Recommendation Report for Planning Permission for Works or Extension to a Dwelling

REF NO: FP/265/21/HH

LOCATION: 105 Limmer Lane
Felpham
PO22 7LP

PROPOSAL: Single storey rear extension. Replacement porch with balcony above.

Proposed Extension and Alterations
at 105 Limmer Lane, Bognor Regis
for Mr and Mrs N Pearson
Drawing P01 November 2021 Scale 1:100 @ A3
Planning Drawing - Ground Floor Plan and Elevations

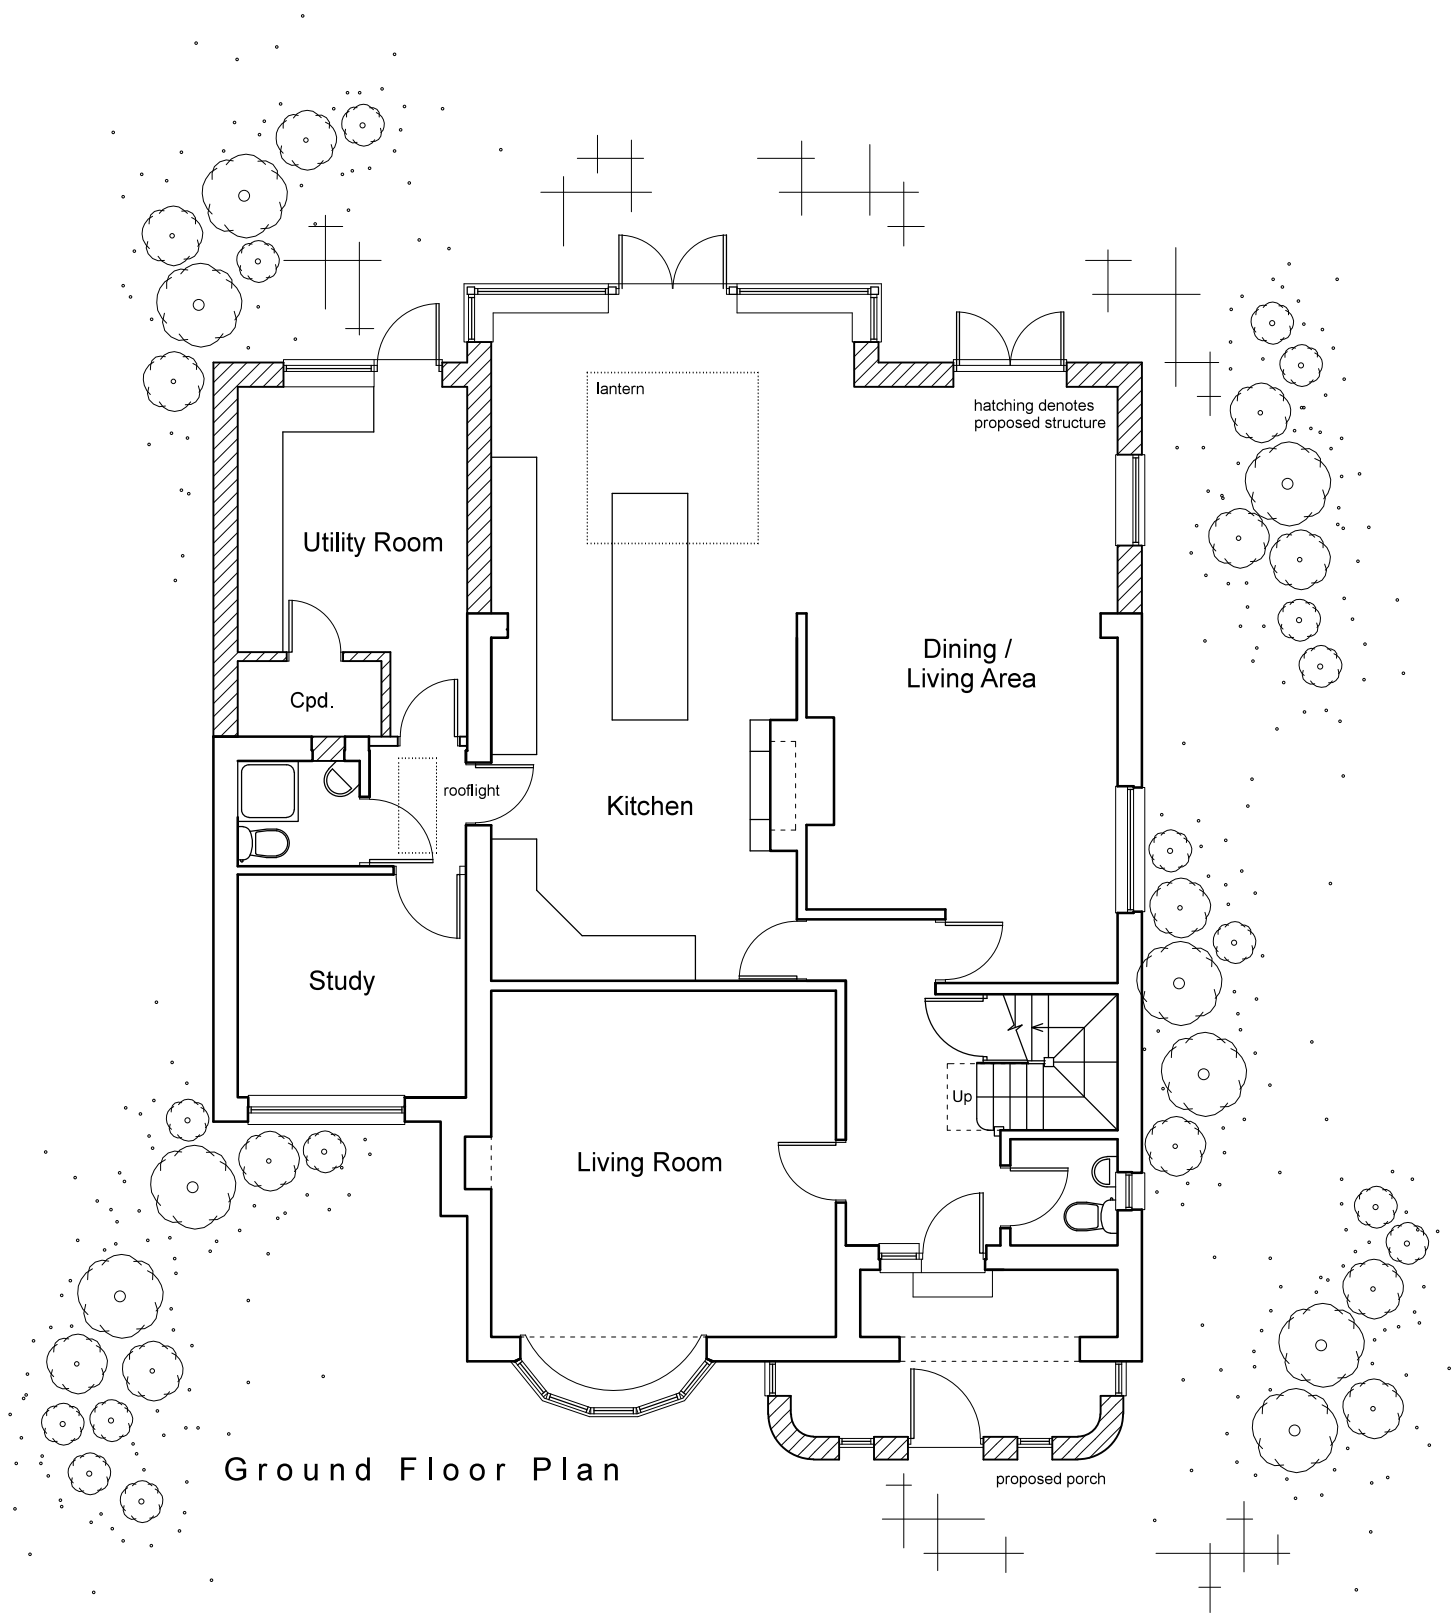
The rear single storey extension extends the full width of the dwelling, projecting approx. 3.4m to approx. 4.3m off of the rear dwelling, retaining 24m of rear amenity space. The height of the proposal is approx. 2.9m in height, featuring a flat roof and 2 No. skylights. This component is not subservient but is appropriate in scale given the scale of the host dwelling and the site. The proposal is visually integrated, featuring materials that match those of the existing dwelling. The proposal is to the rear of the property but will have views from the street albeit limited, as it is a corner dwelling.

The rear single storey extension retains 1.2m to the western boundary. The proposal does not intersect any neighbouring 60 degree sightlines. The scale of the rear component and sufficient spacing to the western boundary, results in the rear component giving rise to no adverse impacts by way of overbearing or overshadowing on the neighbour dwelling to the west. The rear component features rear facing glass doors and windows, these give rise to no adverse impacts by way of overlooking.

Proposed Extension and Alterations
at 105 Limmer Lane, Bognor Regis
for Mr and Mrs N Pearson
Drawing P03 November 2021 Scale 1:100 @ A3
Planning Drawing - First Floor Plan and Elevations

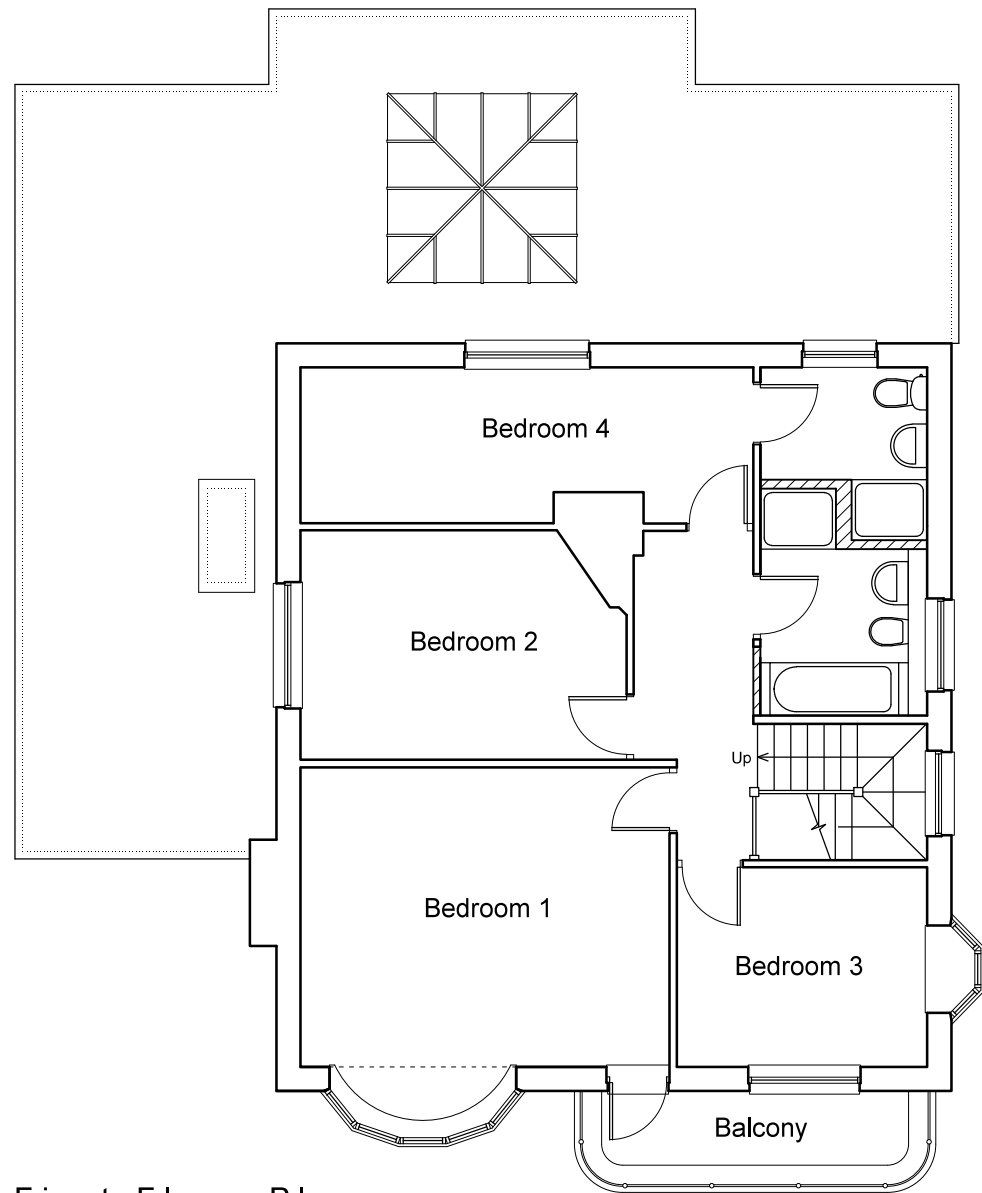
The proposed front porch replacement is of similar scale to the existing porch, increasing slightly in height from approx. 2.8m to approx. 3.2m and featuring a balcony. The scale of this component is appropriate. The design features appropriate design and matching materials to those found on the host dwelling. As such, although visible from the street, this component is visually subservient, integrated and gives rise to no adverse impacts on the street scene.

The Front porch replacement with associated balcony is of similar scale to the existing porch, giving rise to no adverse impacts by way of overbearing or overshadowing on neighbouring properties. The balcony is to the front of the dwelling and as such, provides lookout over the street. It does not give rise to any adverse impacts by way of overlooking on neighbouring private amenity space.
